City of Portland, Maine – Building or Use Permit Application 389 Congress Street, 04101, Tel: (207) 874-8703, FAX: 874-8716

BUILDING PERMIT REPORT

DATE: 1 July 98 ADDRESS: 122 Spring ST, 039-D-004
REASON FOR PERMIT: Signage
BUILDING OWNER: Arthur Alehsime
CONTRACTOR: Oscar Mokeme
PERMIT APPLICANT: _____
USE GROUP Signage BOCA 1996 CONSTRUCTION TYPE _____

H. 2' x L. 21' x $\frac{3}{4}''$ MDO

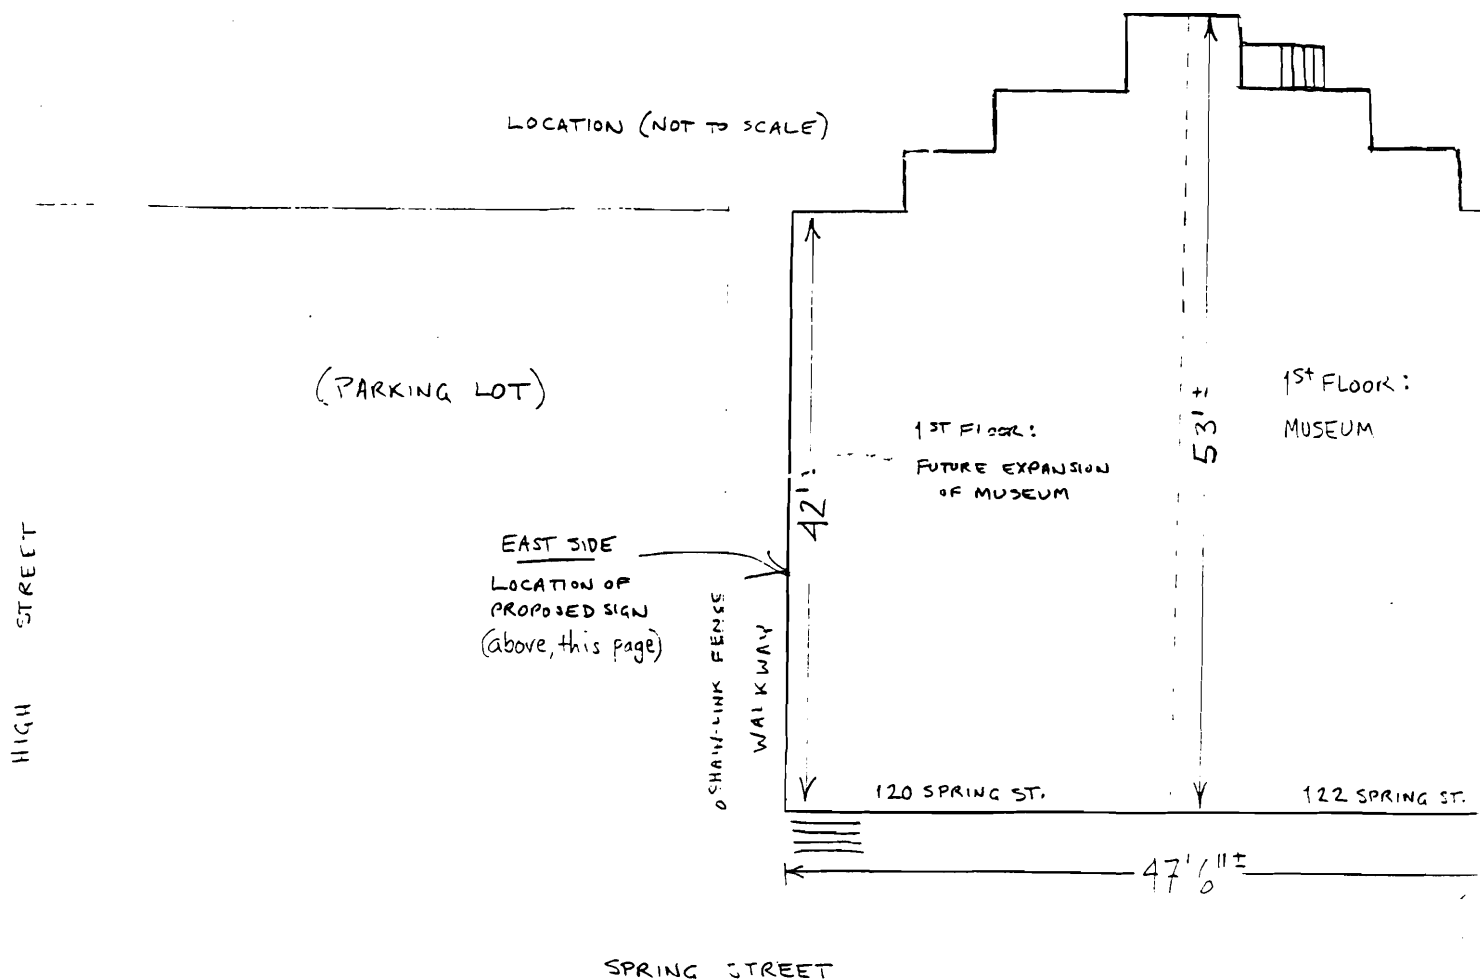
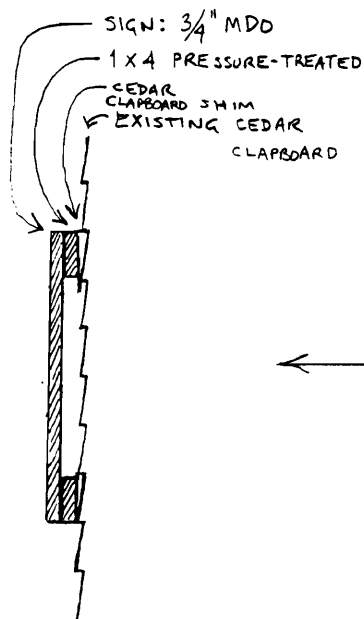
all signs DENIED

- * 29. wall sign denied as per Historic Preservation -
- * 30. Your proposed sign application did not have any structural details - Please submit these for approval before sign is hung.
